**SUBJECT: Ellicott Town Center – Filing No. 1  
Response to County Review Comments  
SF-18-025**

In conjunction with our Filing No. 1 final plat re-submittal, this letter provides responses to the County review comments discussed in the Memorandum from PCD-Engineering dated February 22, 2019. These comments are specifically addressed as follows **(Applicant responses are annotated in bold / red / parenthesis following each County comment):**

FILING 1 GRADING & EROSION CONTROL PLAN

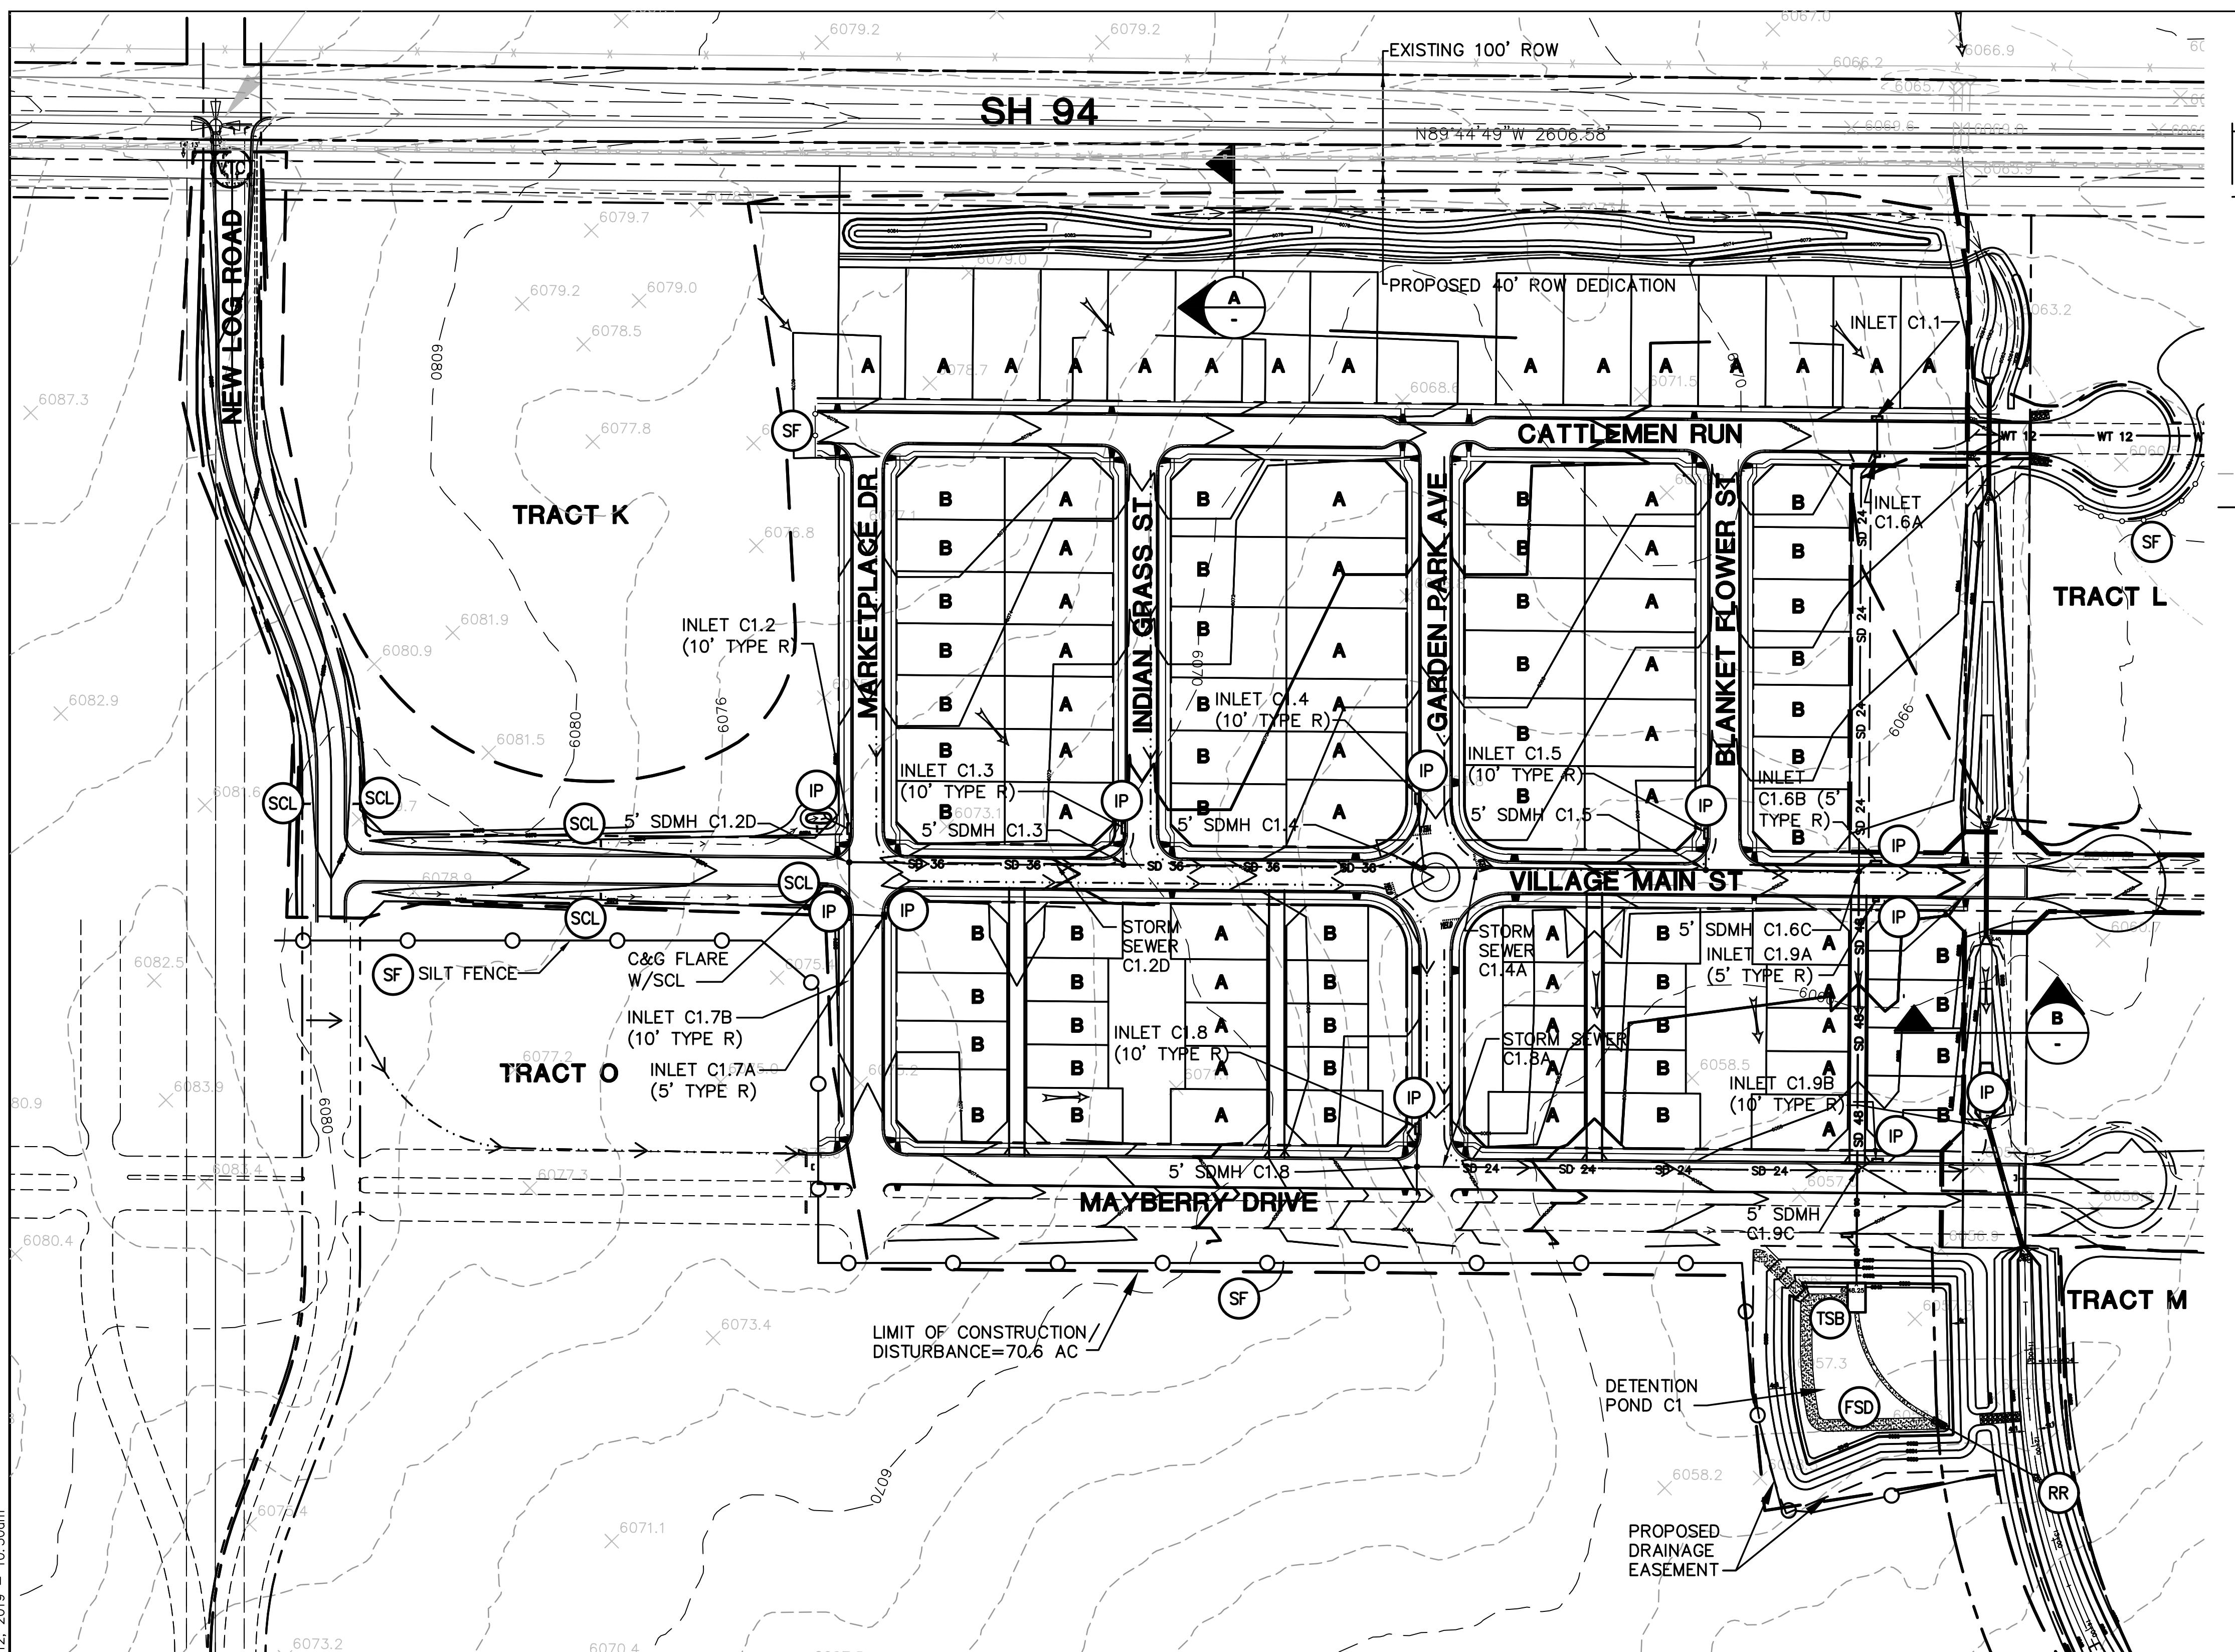
1. Provide a SWMP. **Provide when available. Update the ESQCP application information. (Provided)**
2. Ensure that all GEC Plan and SWMP checklist items (attached) are provided. GEC and SWMP checklists will be reviewed in detail with the next submittal. **Note: due to the amount of time required to review the other submittal items, the checklists will be verified with the next submittal. (Updated checklists provided)**
3. Show and label maintenance access roads on the plans. **Unresolved; see redlines. (Provided per redline comments)**
4. See GEC Plan redlines. **See updated redlines. (Redline comments have been addressed)**

TEMPORARY POND C2.8 PLAN

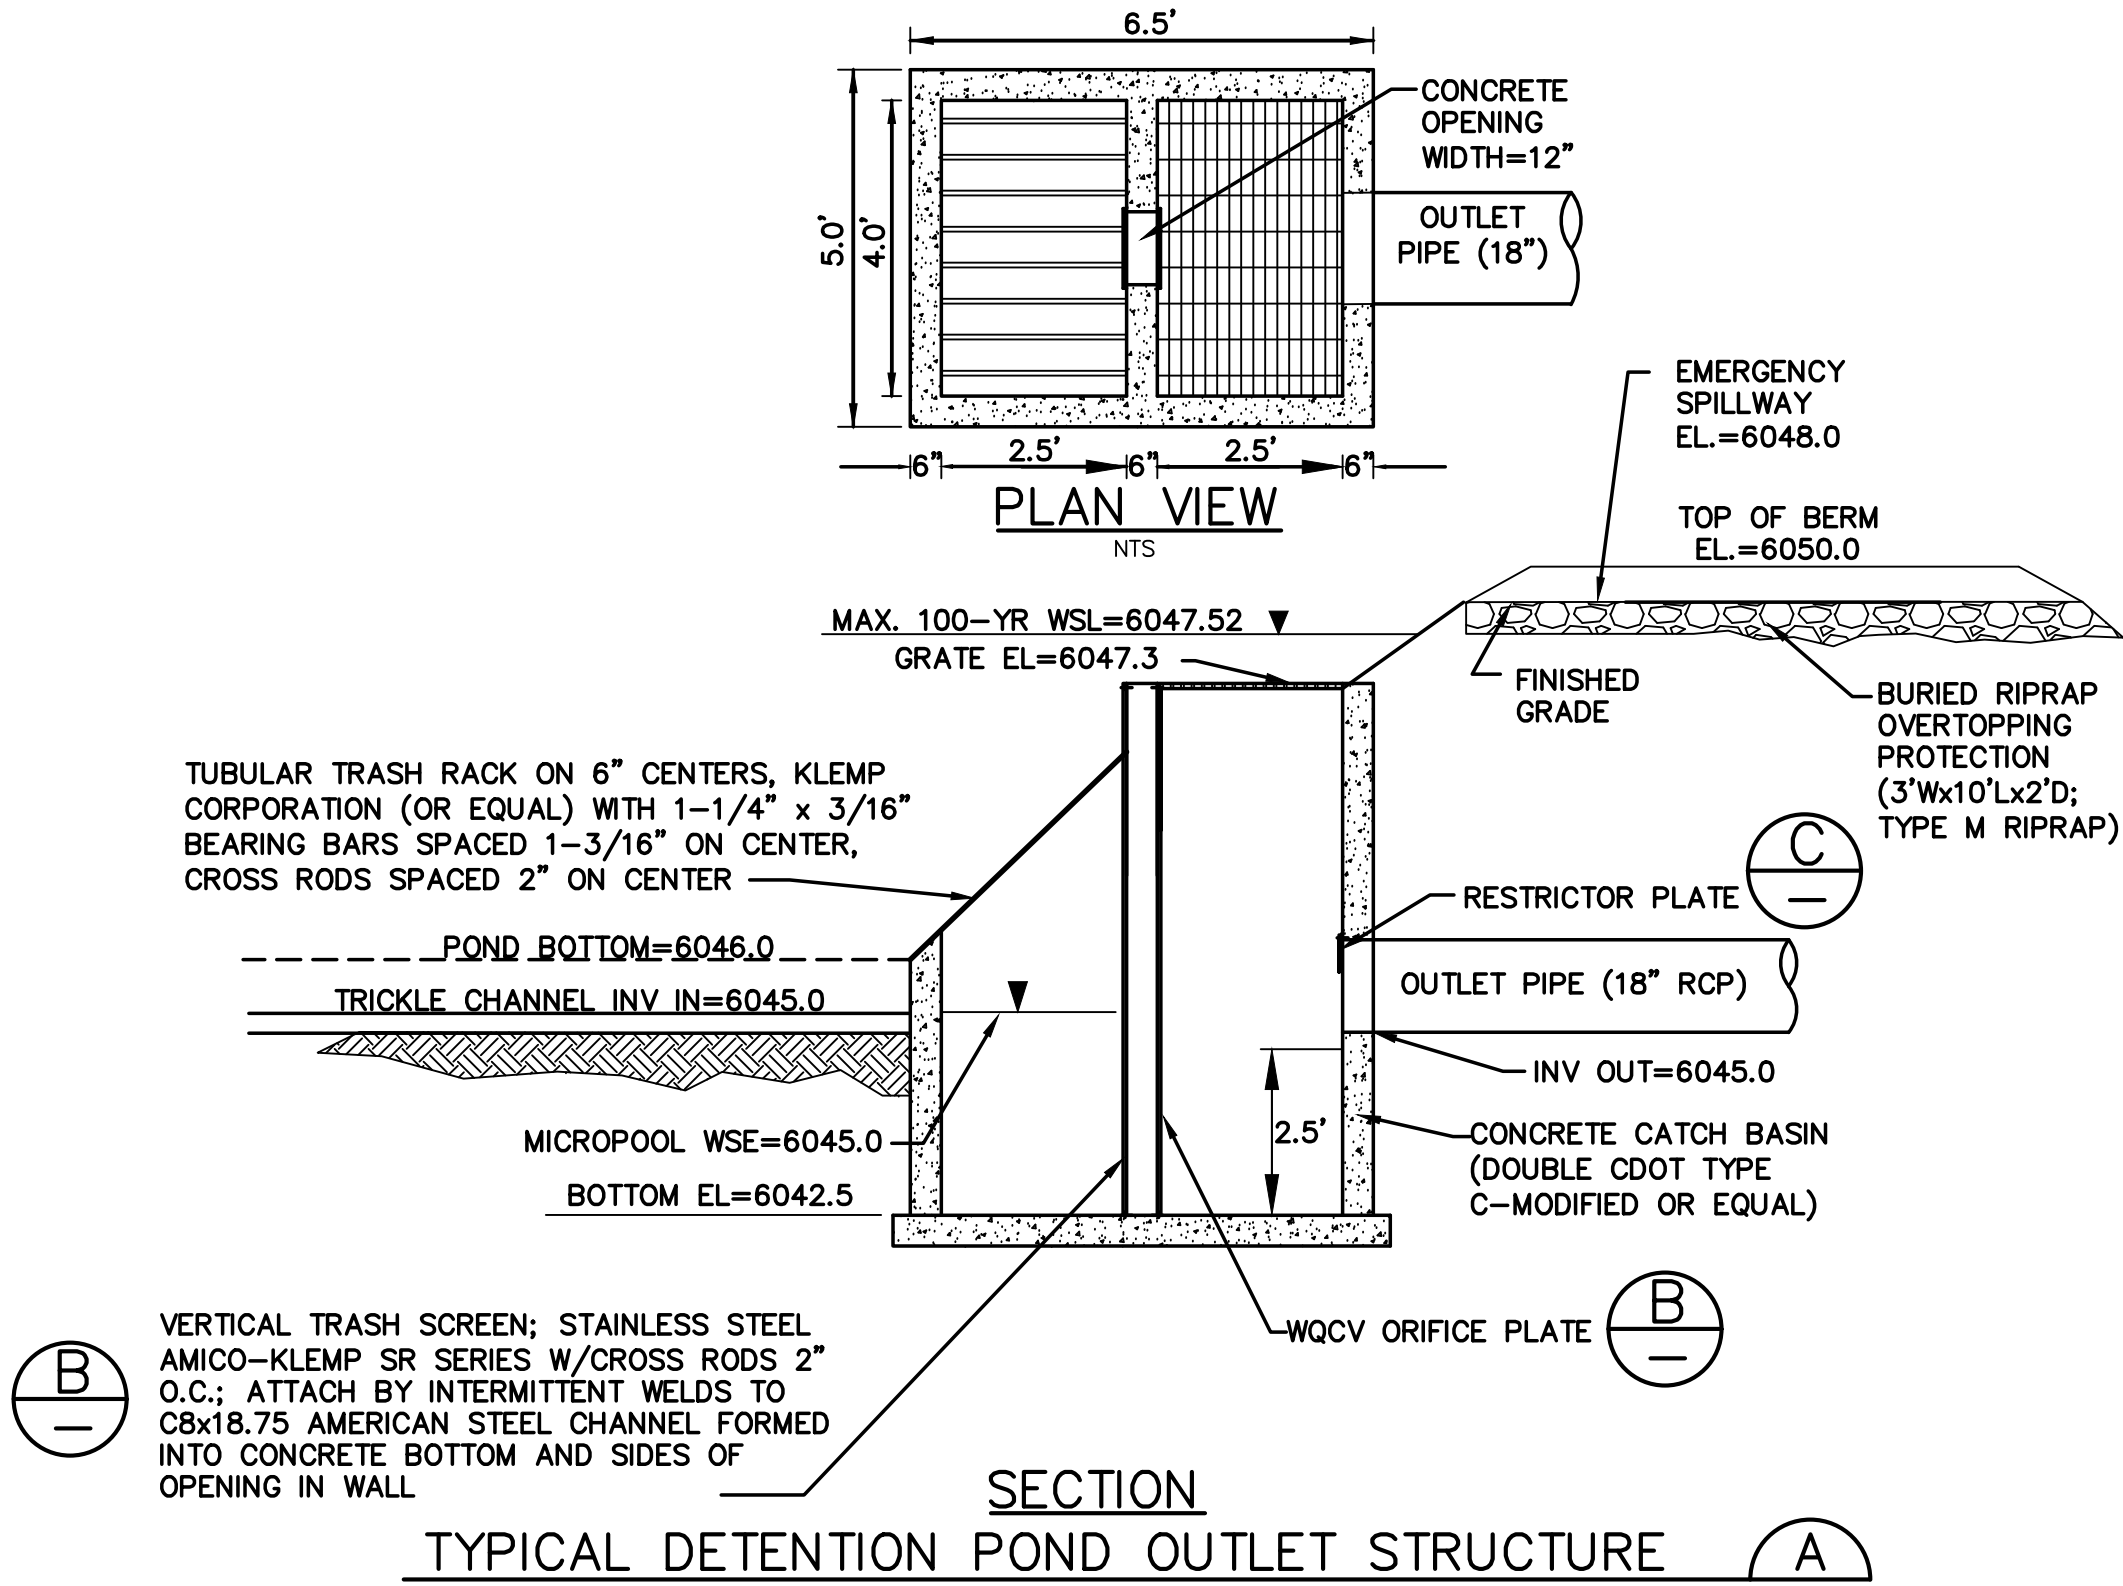
1. See the revised PDB/BMP Maintenance Agreement and Easement. **Provide Exhibit B, and provide an agreement for the added temporary Pond C2.8. (Provided)**
2. See FAE redlines. Note: quantities and costs will be verified with next submittal. **See updated redlines. (Redline comments have been addressed)**
3. See attached final submittal checklist for reference.
